DECISION DELEGATED TO HEAD OF PLANNING
DECISION DELEGATED TO HEAD OF PLANNING
DECISION DELEGATED TO HEAD OF PLANNING

Application No:	H16-1080-23	Applicant:	Ringwood & Simpson Ltd
Proposal:	Erection of detached dwelling and garage - approved under H16-0047-23. Modification of Condition 2 to allow amendments to previously approved plans		
Location:	Rear Of 175 Hawthorn Bank Spalding		
Terminal Date:	31st January 2024

Drawing No.
2474-11A

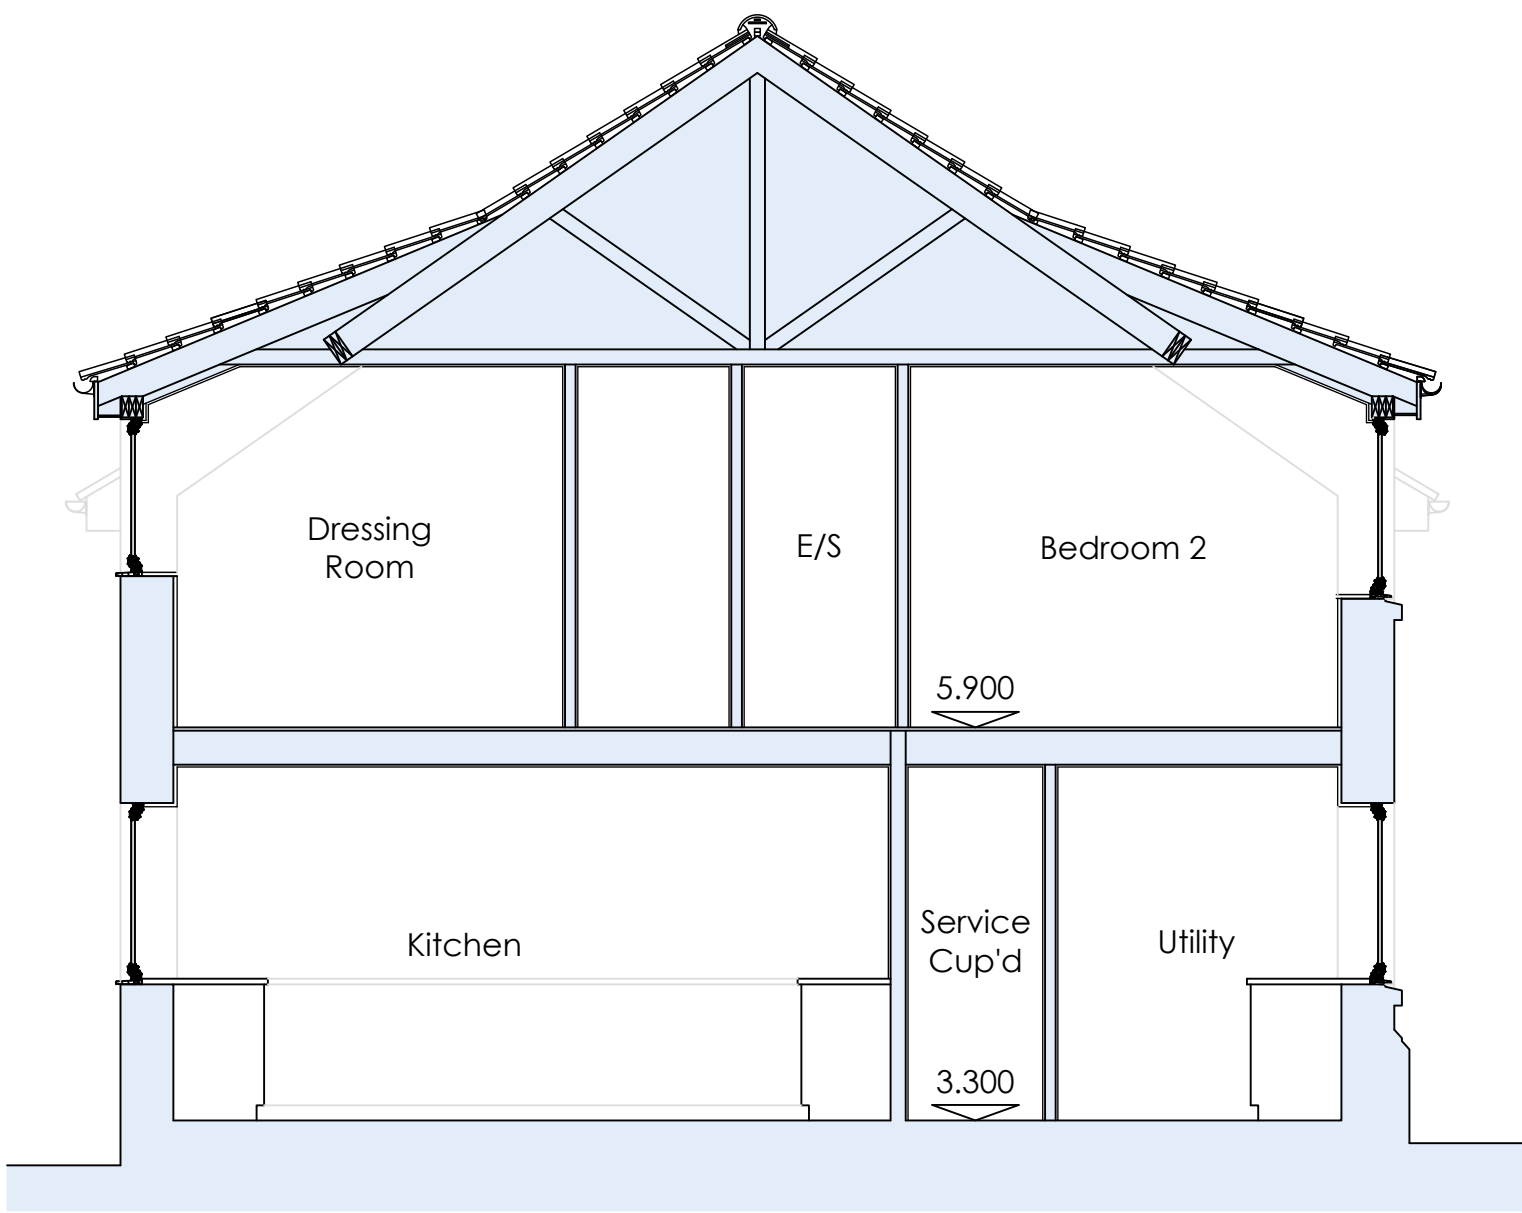
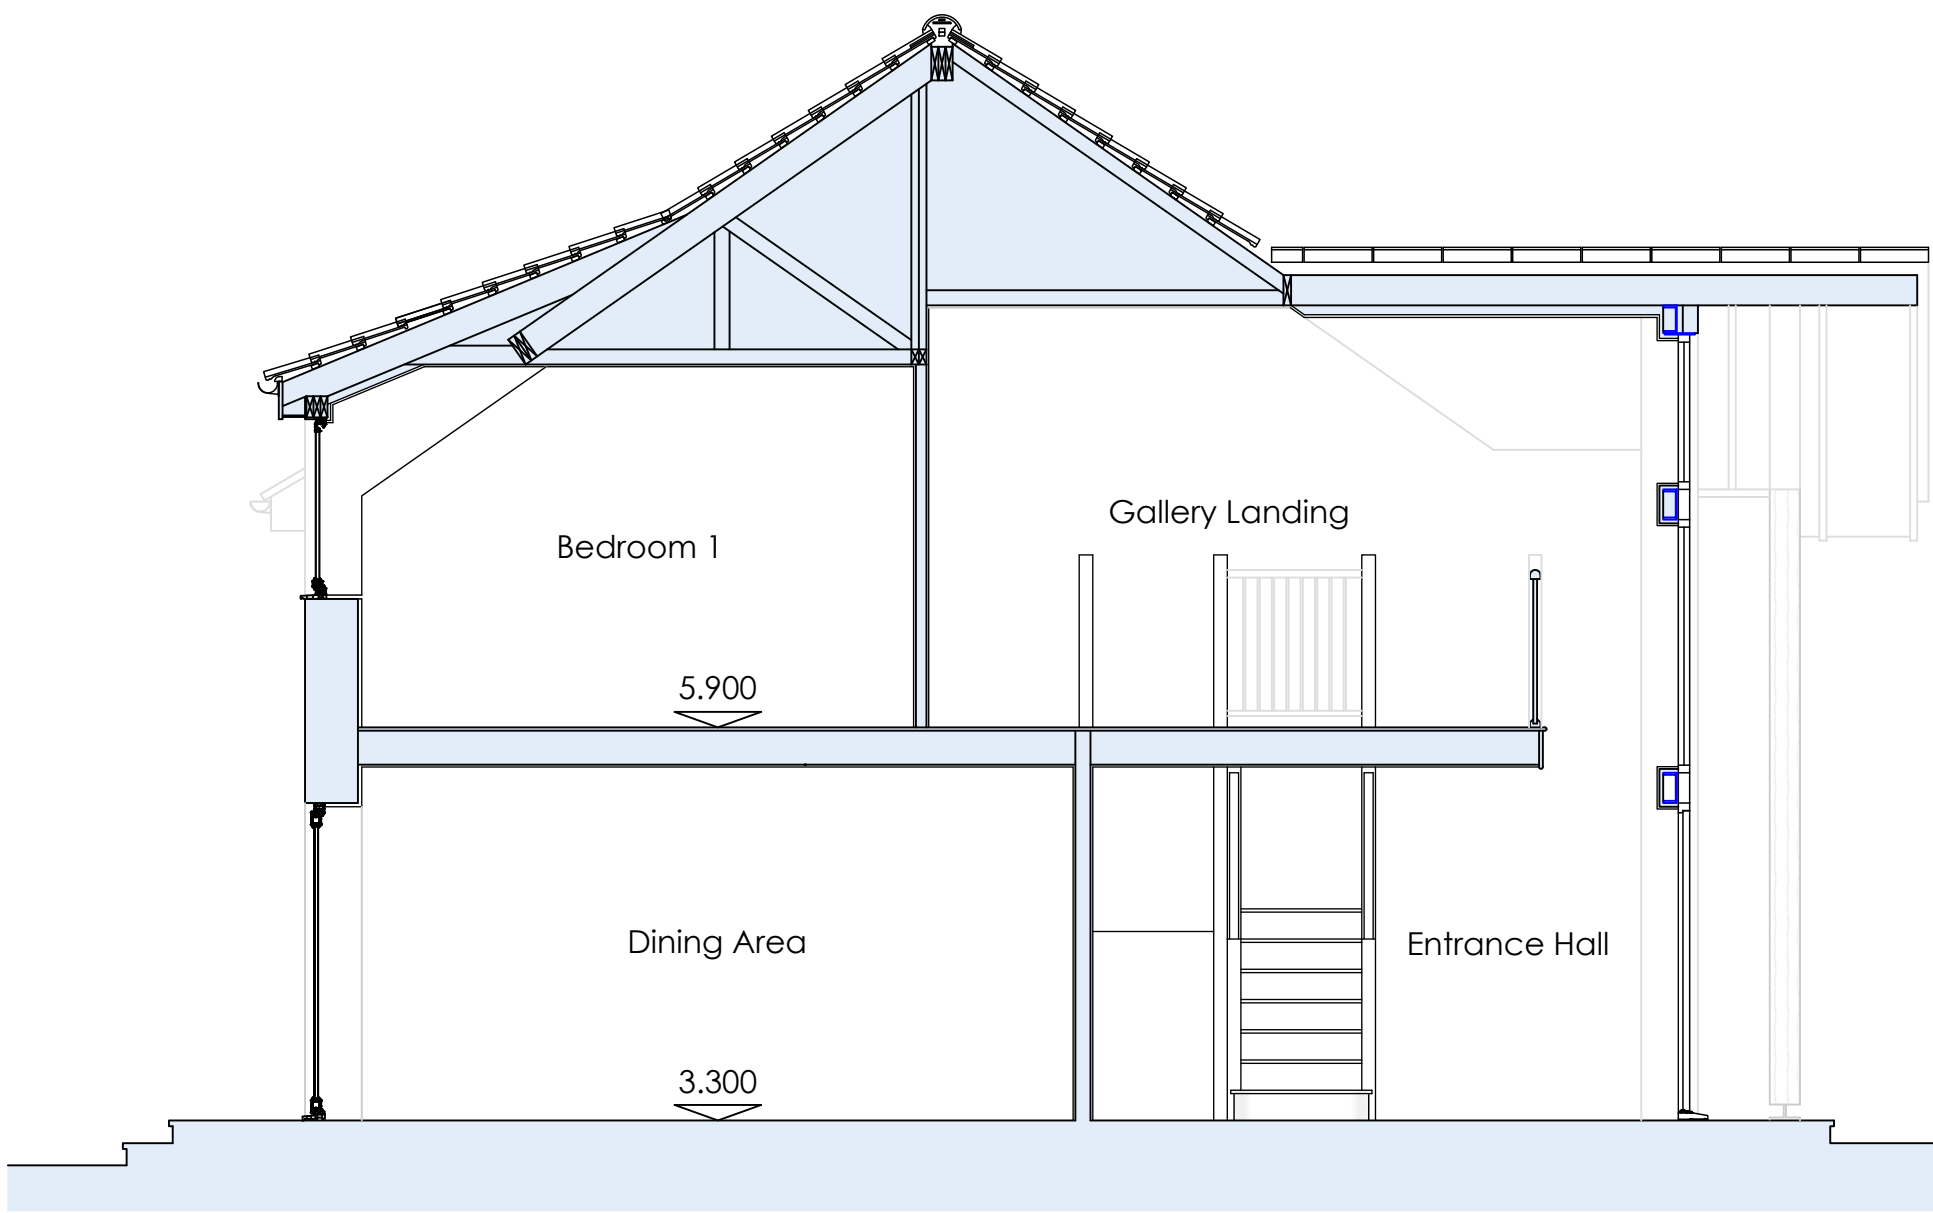
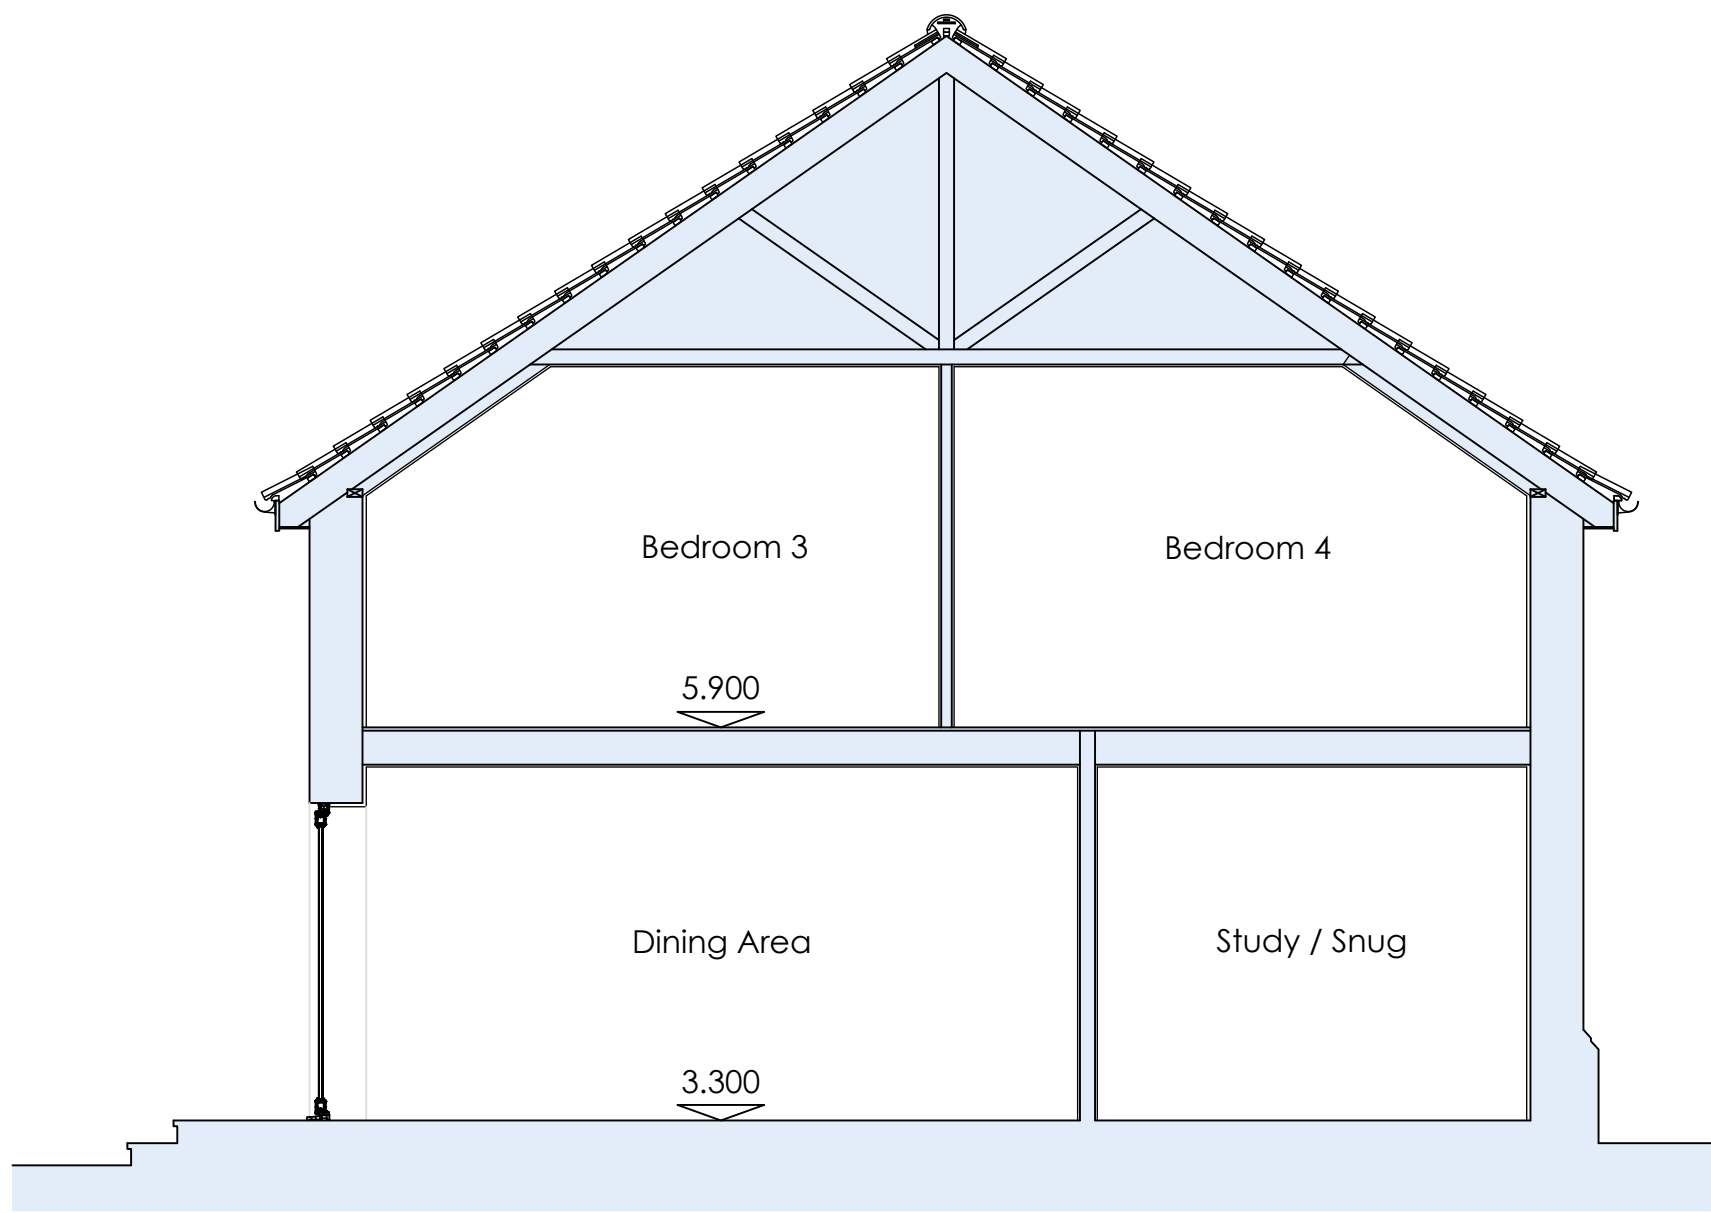
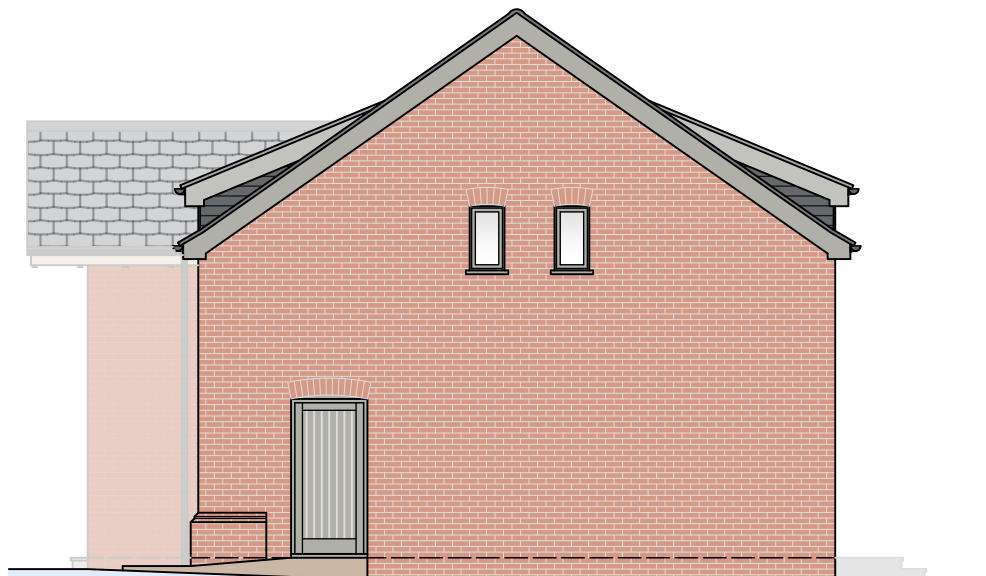
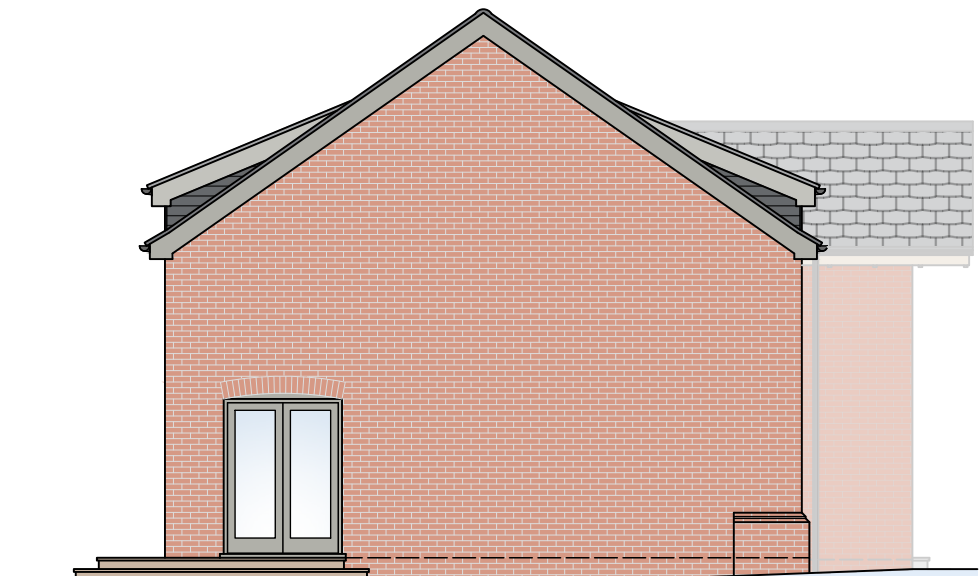
The dwelling is located on a similar footprint to what has been previously approved, the scale is also comparable, however this proposal seeks a slightly taller dwelling, though this is slightly mitigated by the ability to built to finished floor levels of 3.3m AOD (a topography plans now shows the existing site levels are set at circa 3.00m AOD, lower than previously assumed within the FRA).

Architecturally the dwelling now exudes a greater symmetry with a central two storey entrance porch which contains an internal 'galley' balcony area at first floor. 1st floor openings straddle the eaves creating catslide style dormers (this keeps the overall height down), two of which are located on the principal elevation and 4 on the rear elevation. Two sets of bi-folding doors are located to the rear and exit onto a raised area which steps down into the garden. There are also steps leading up to the main central entrance on the front.

The proposed changes to the dwelling itself are considered acceptable, the palate of materials and the central porch would provide a dwelling of high merit. The boundary treatments surrounding the rear amenity, which are proposed to be at 2.1m are considered to have a mild character effect, especially upon adjoining neighbours visual amenity. This impact however is localised and the separation distance from the neighbouring dwellings to these boundaries mitigate unacceptable harm. It should be noted that 2m boundary treatments are available to future residents through applying PD rights.

The proposed dwelling which slightly taller would not result in an unacceptable impact upon neighboring amenity through overshadowing/overbearing when considering what is already approved on site. The location of openings are commensurate with those previously approved. The dwelling however has set finished floor levels at 300mm above existing ground levels (as required by the FRA), following the site being surveyed these levels are 3.3mAOD. It is considered that this is acceptable. The proposed fencing to the rear boundary is 2.1m in height and this is also acceptable. The impact from the car port is considered acceptable, commensurate with what is allowed under previous permissions.
